BARGHAUSEN

RE: Responses to Comments
White Barn – Chick-Fil-A
Highway 9 and Soper Hill Road, Marysville, Washington
Permit No. PA23-019 / Our Job No. 22579

The following outline provides each of your comments in italics exactly as written, along with a narrative response describing how each comment was addressed:

SHEET **PRELIMINARY SITE PLAN**

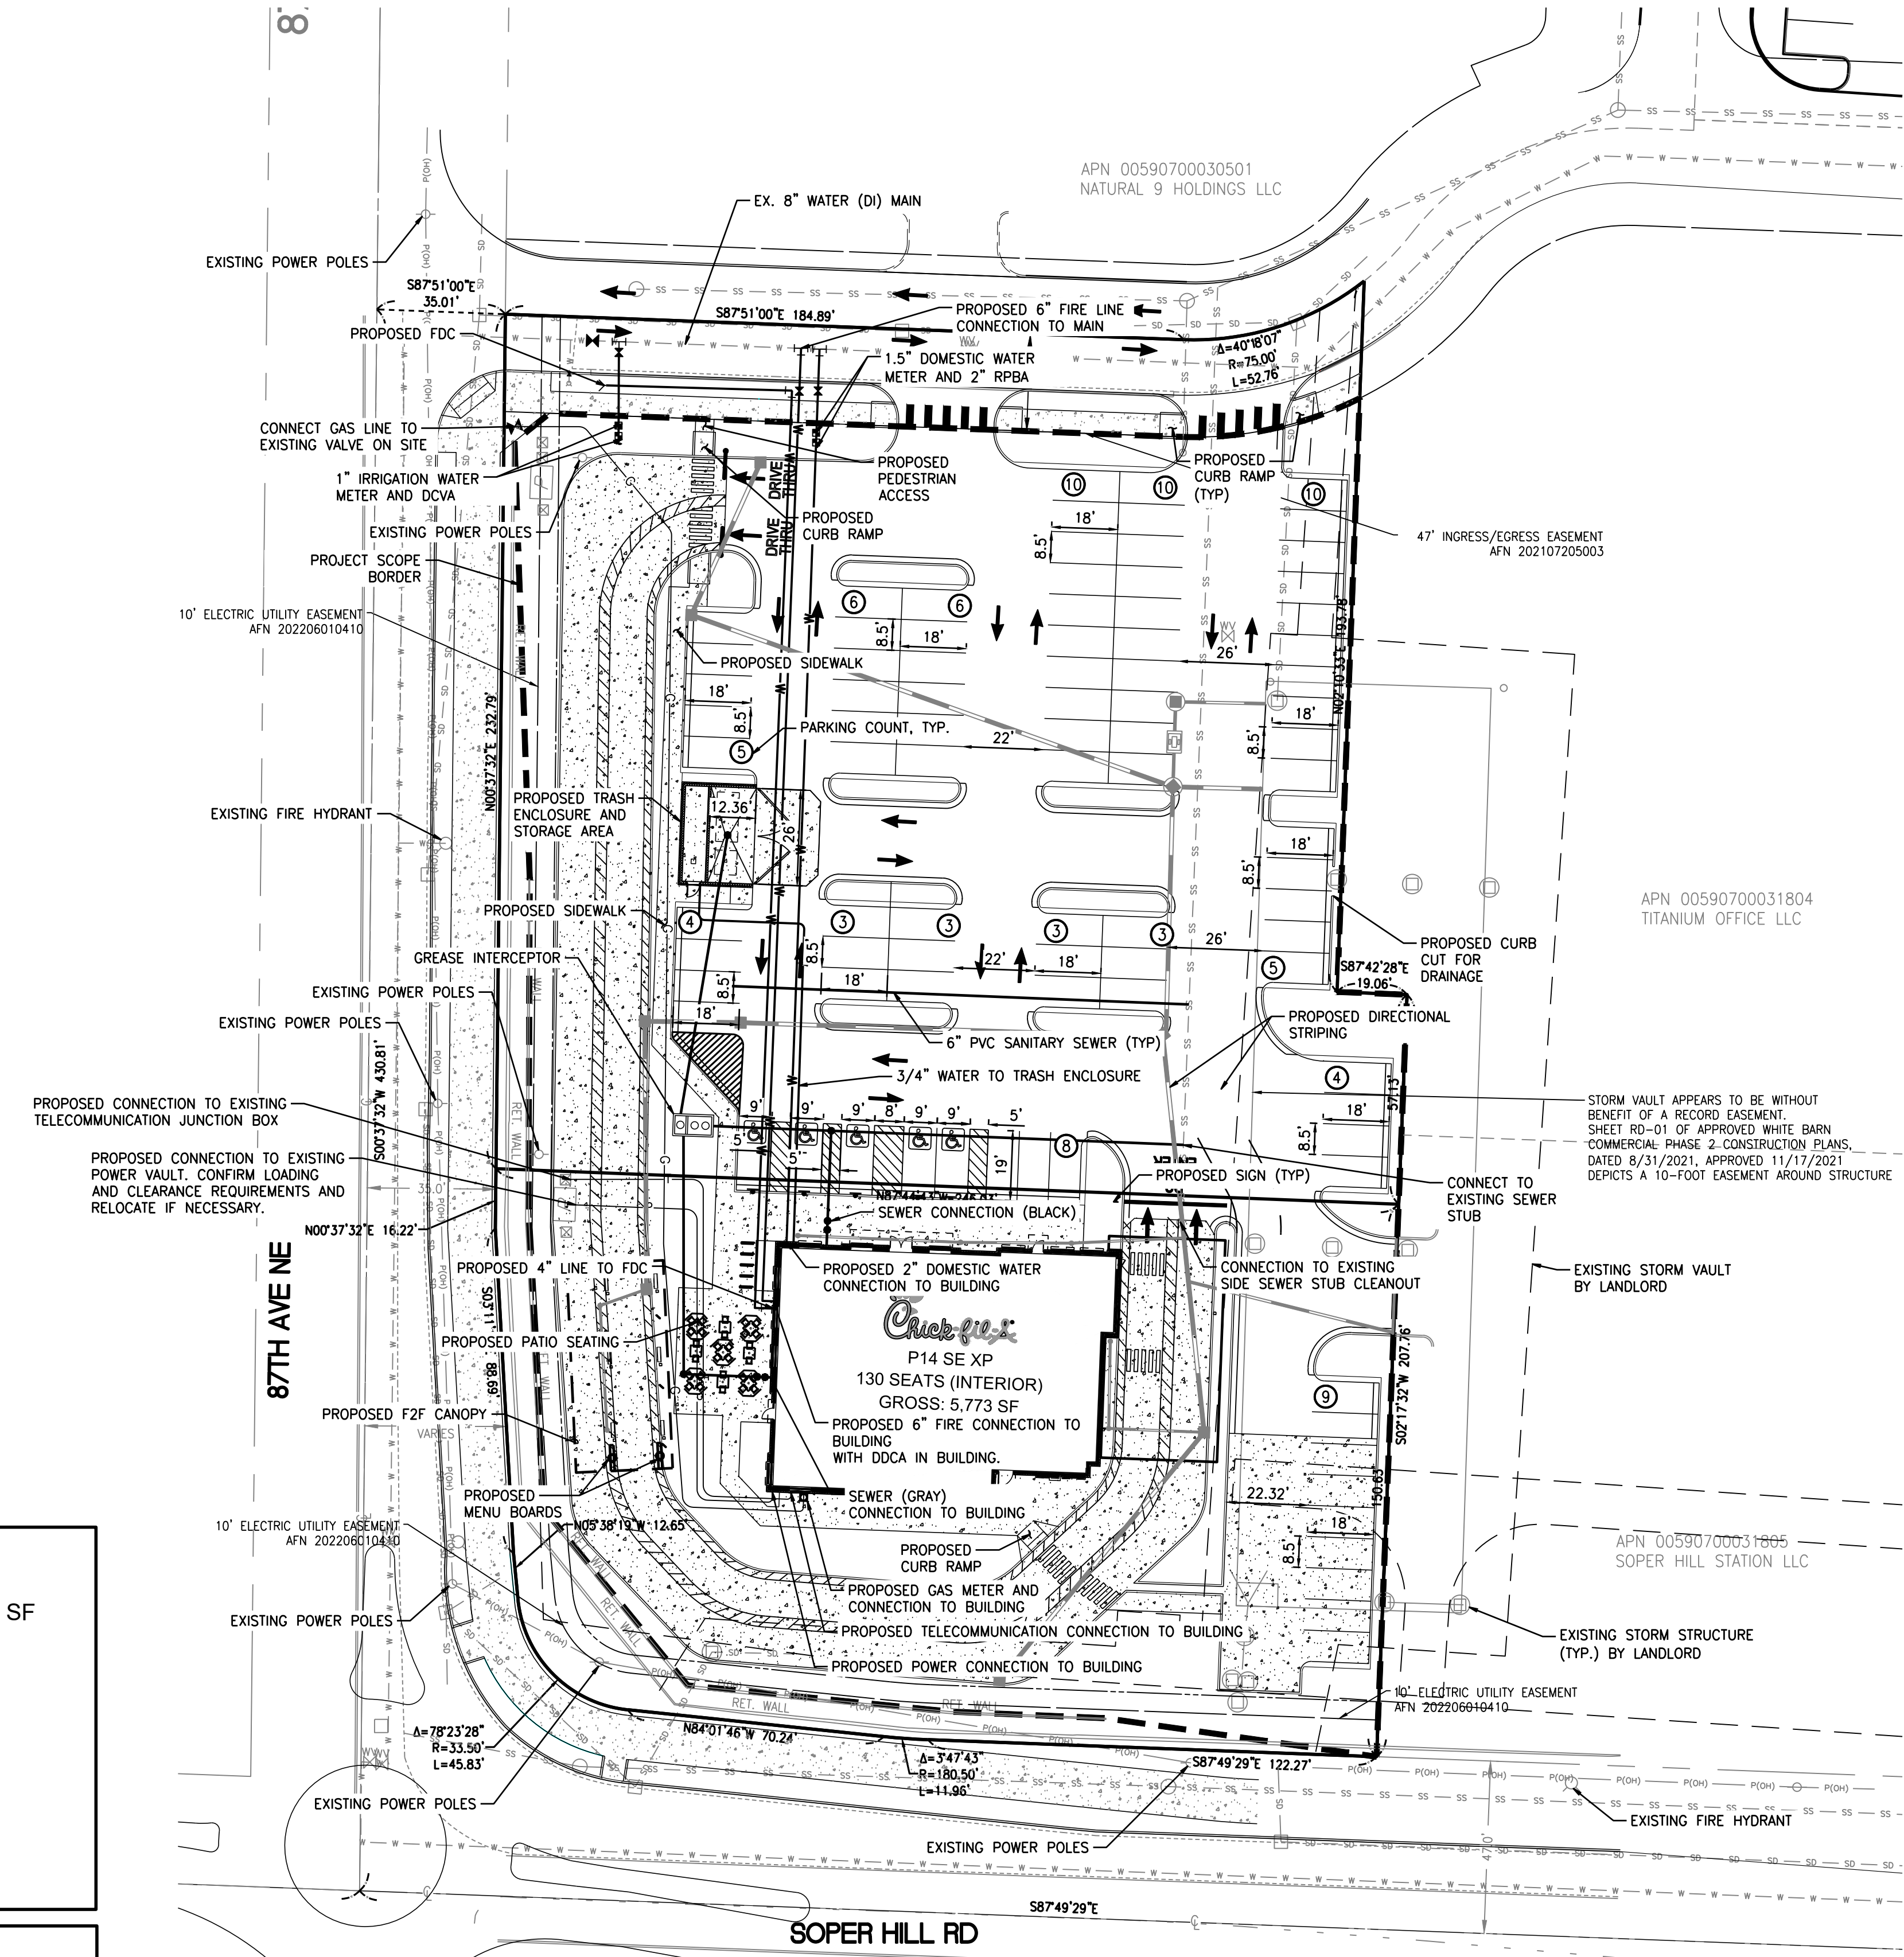
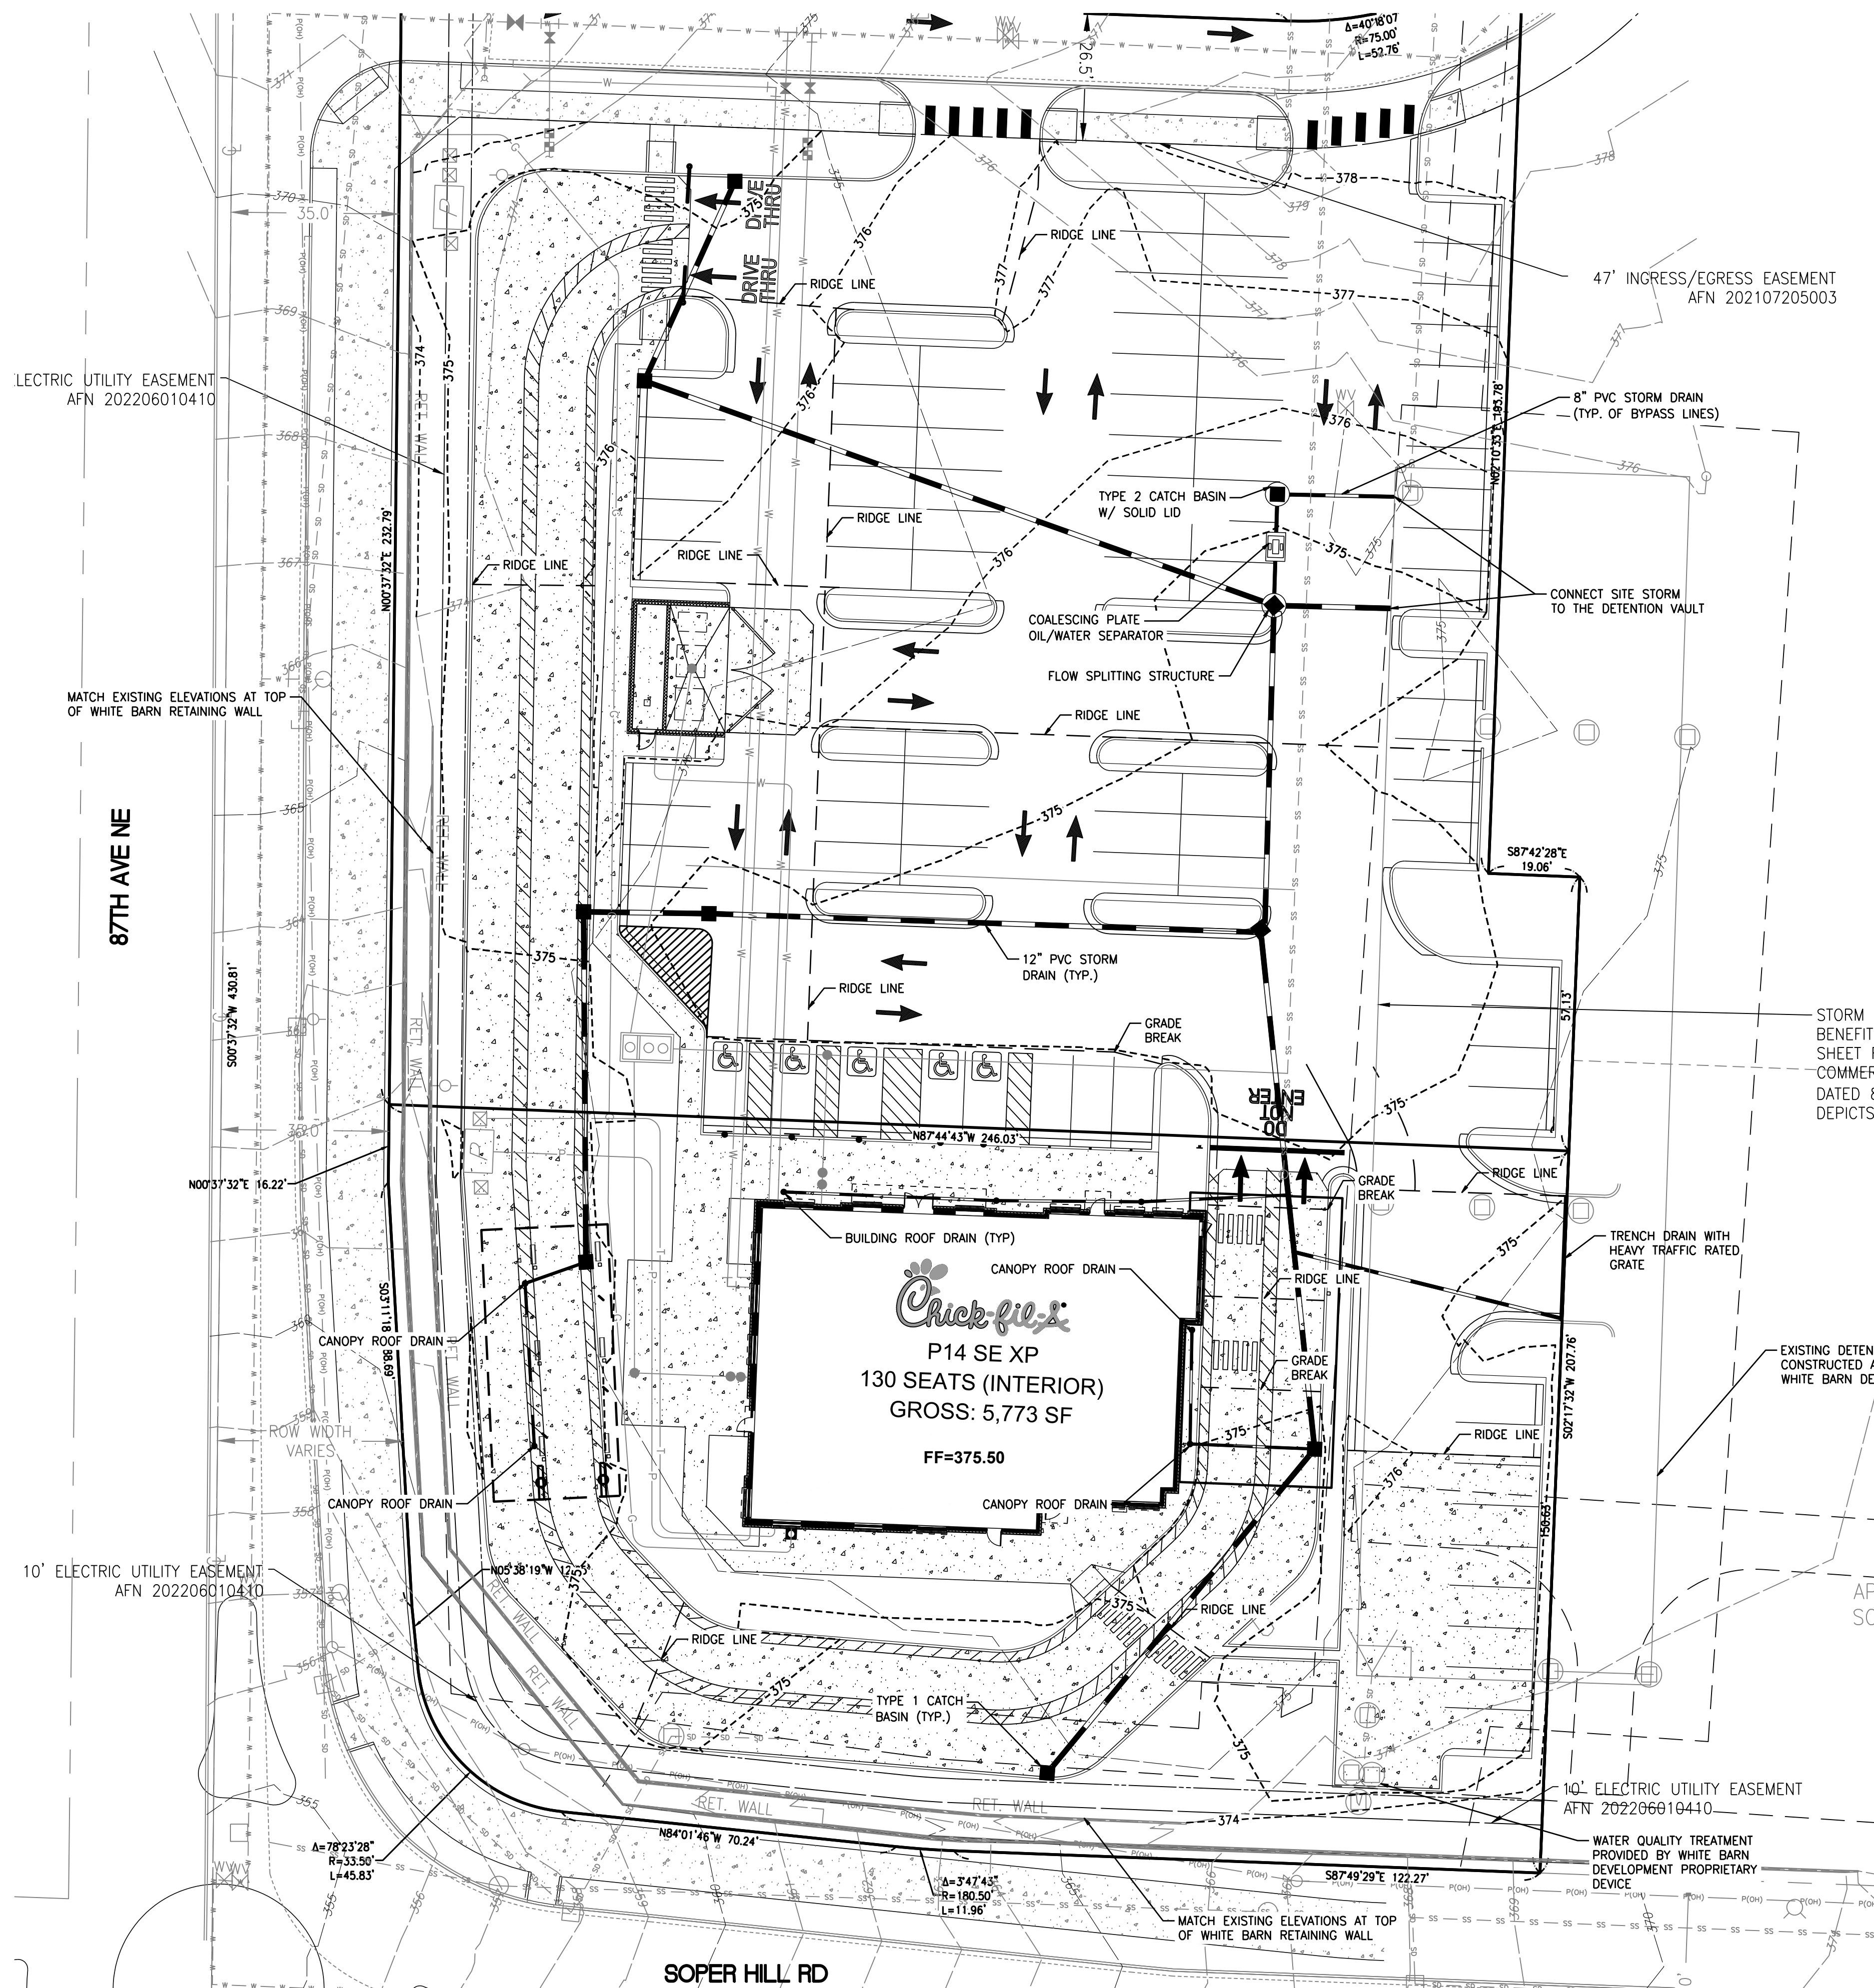
2. *Sheet C1.0 is too busy to review. Provide a clean version, by removing a majority of the notes and arrows, so staff can review to determine compliance with the applicable design standards and setbacks. Once a clean version is received staff will provide comments on the site plan. The following comments that were provided during pre-application review still apply:*

- *Remove Access*

Widen access to three lanes including a dedicated left and right out and eliminate proposed parking. Provide auto-turn to show that the largest vehicle entering the drive-thru can make this turning movement

- *Install LS Island*

- *Provide Auto-turn analysis demonstrating solid waste vehicles can make this movement.*

PRELIMINARY TRUCK TURNS FOR CHICK-FIL-A MARYSVILLE

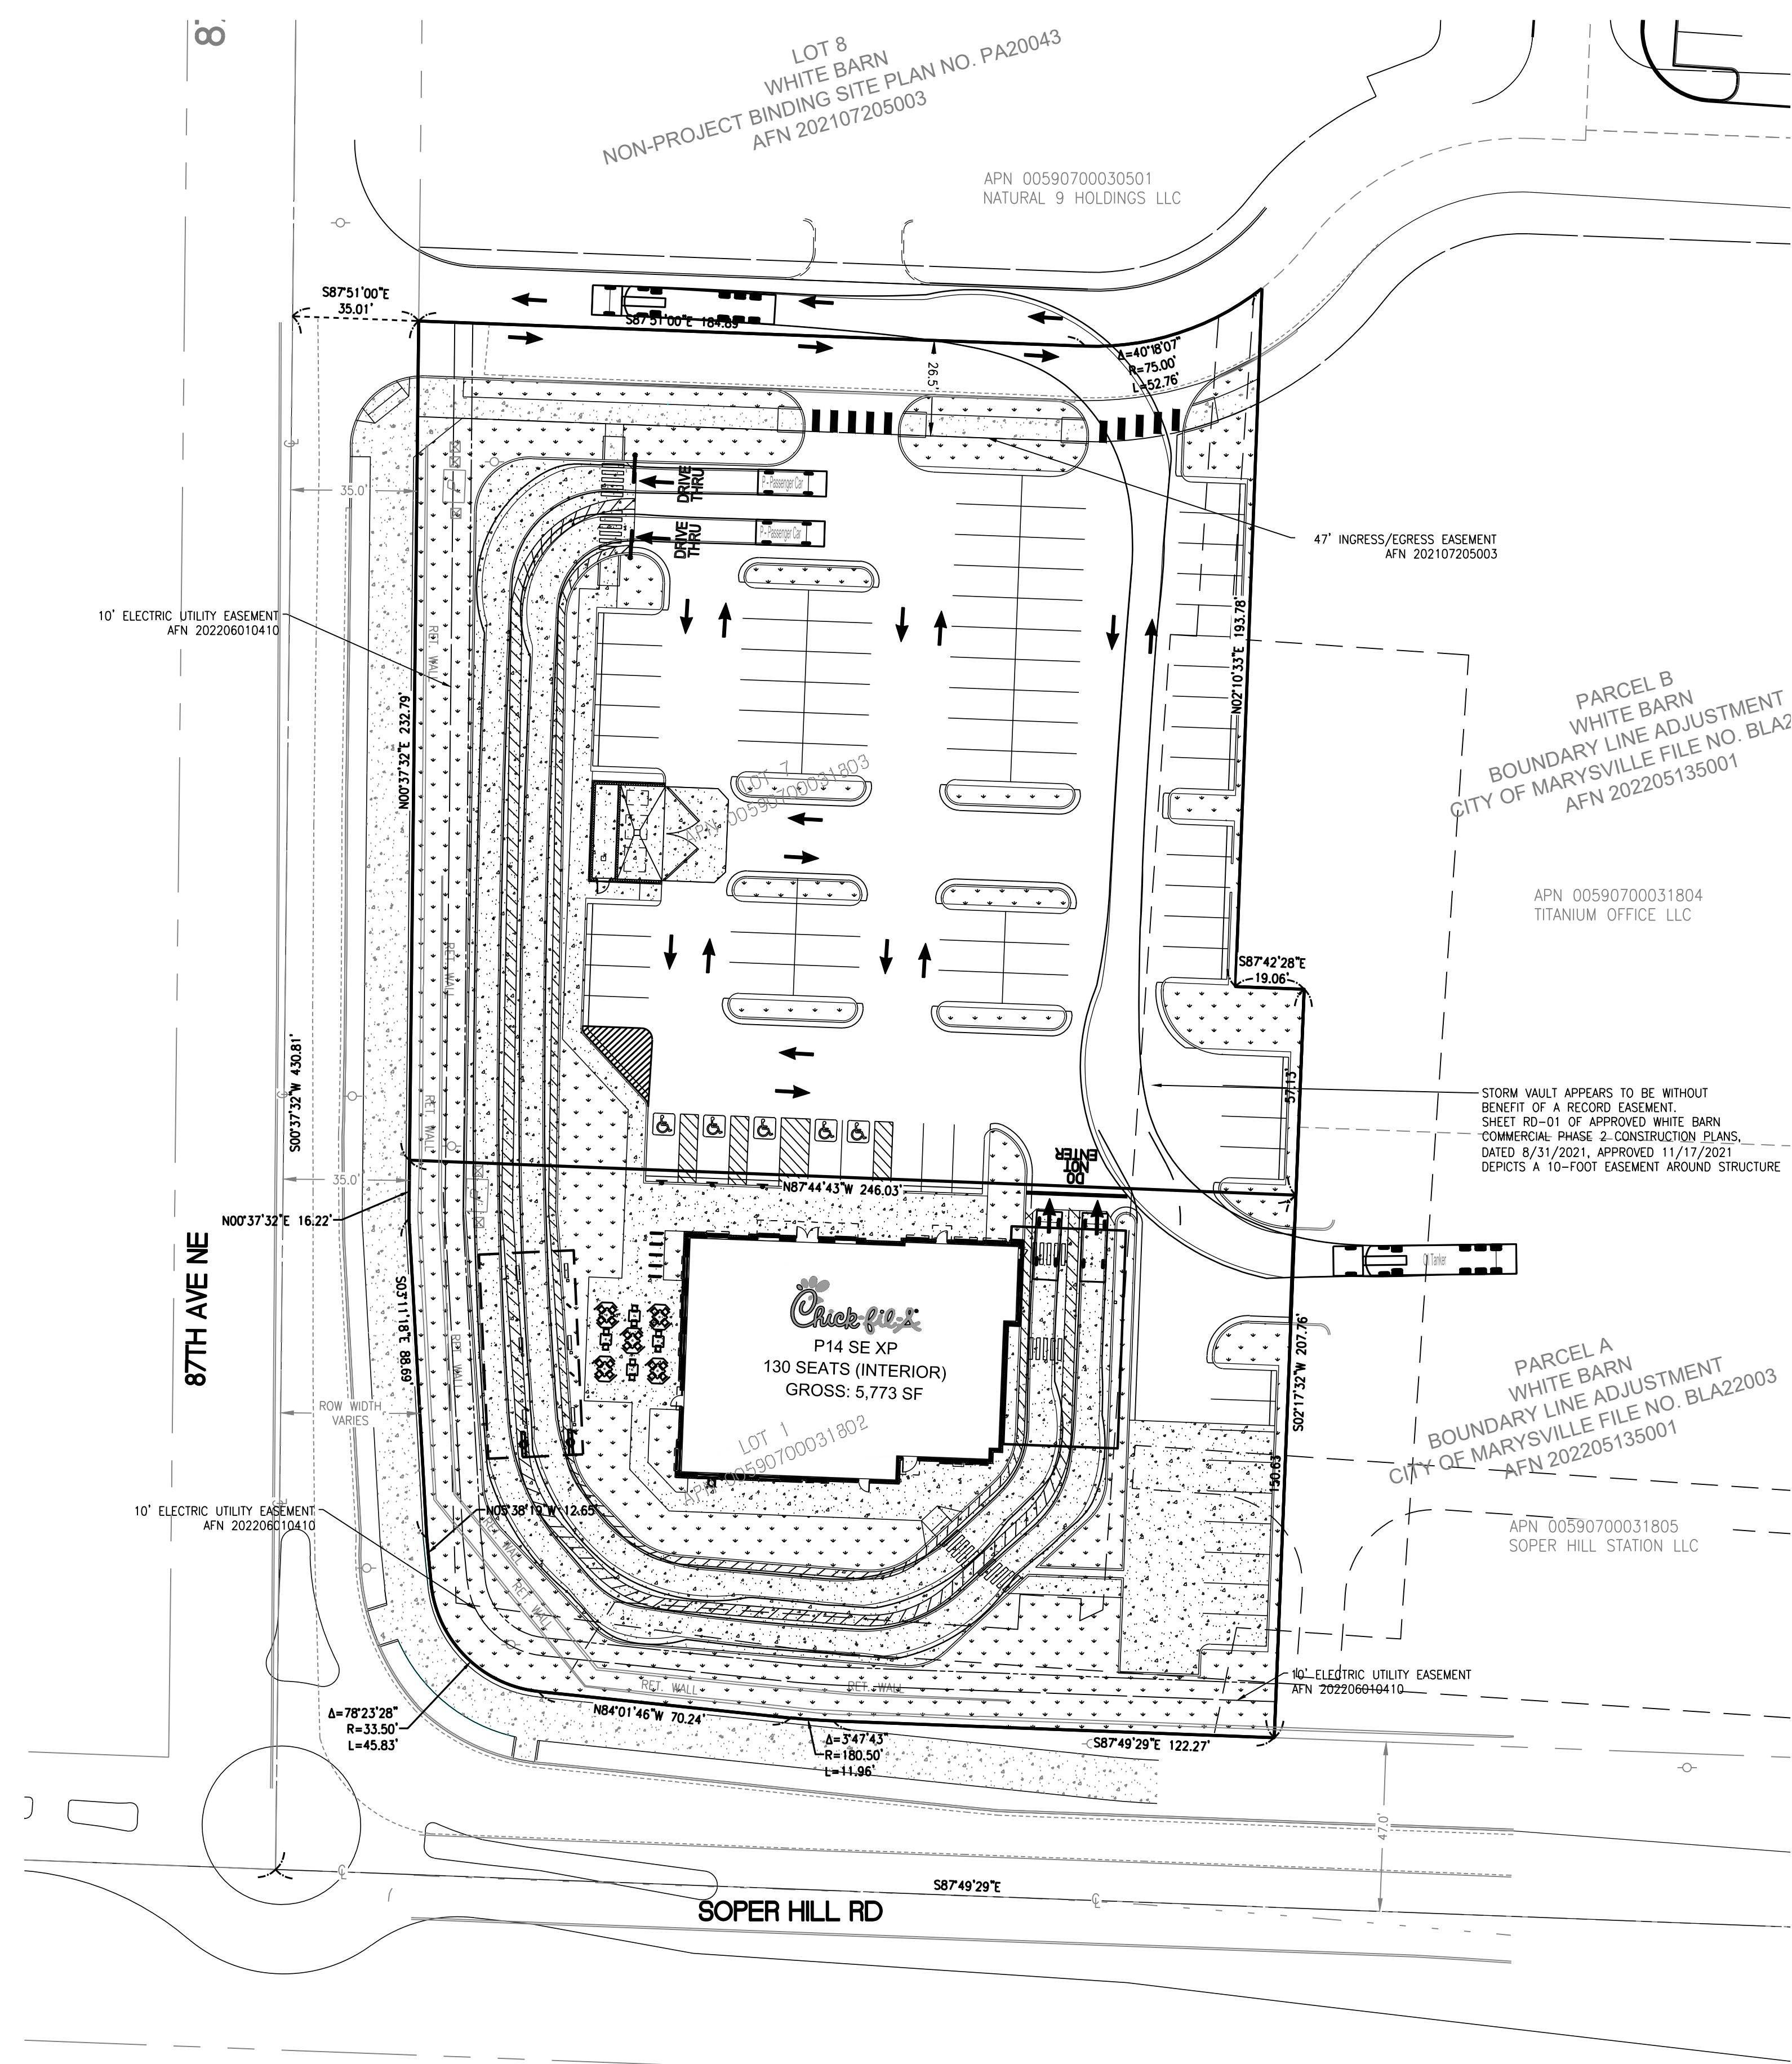
- h. *Provide auto-turn from the north private drive demonstrating the largest vehicles using the drive-thru have adequate turning radius to enter into the drive-thru. The drive-thru appears rather close to the east-west private drive in order to make this turn. Suggested changes included on attached red lined site plan.*

Response: Vehicle turning path is included with the submittal.

Response: The trash hauler route has been included with this submittal.
